## PLANNING CONSULTATION RESPONSE

<b>Application No</b>	2026/0165
<b>Proposal</b>	Erection of agricultural building
<b>Address</b>	Land to the east of Cat Hill Lane, Hoylandswaine, Sheffield
<b>Date of Consultation Reply</b>	20 <sup>th</sup> March 2026
<b>Consultee</b>	Highways DC

STREET SCENE ELEVATION
(WEST)

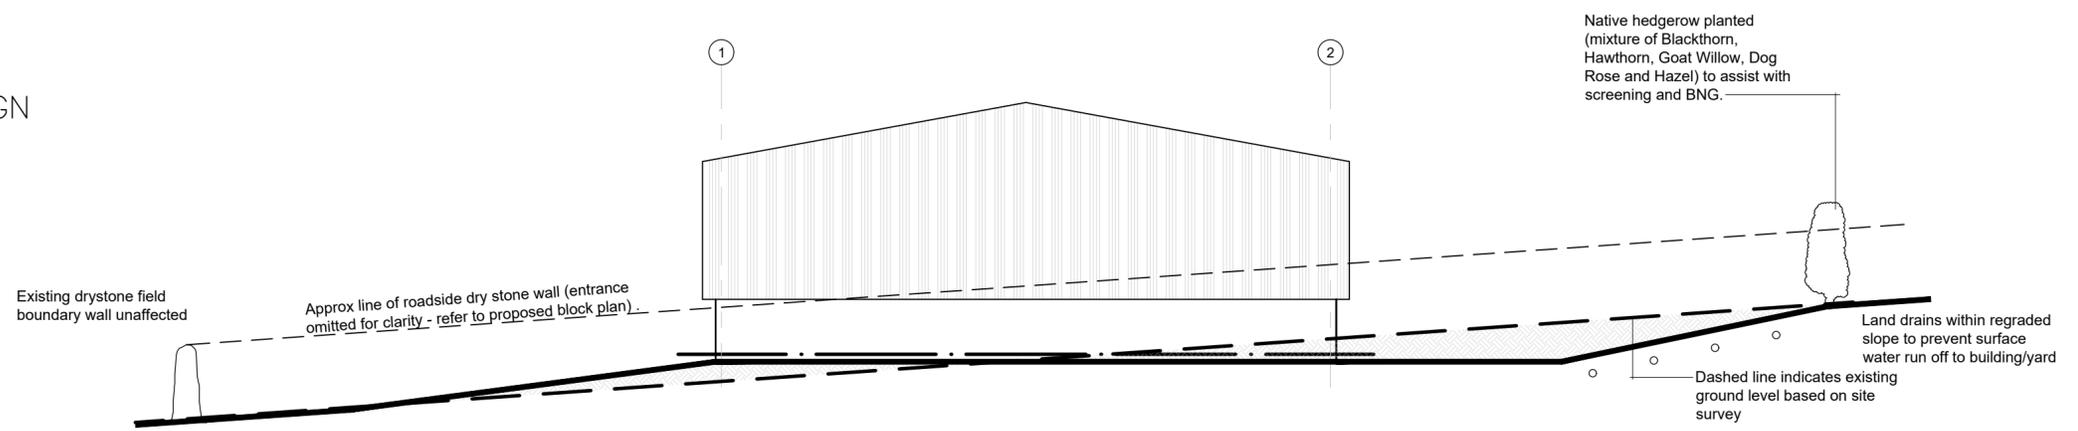
The proposed section of hedgerow within the site is to be set back a minimum of 2.4m from the edge of public highway in order to retain the current level of visibility.
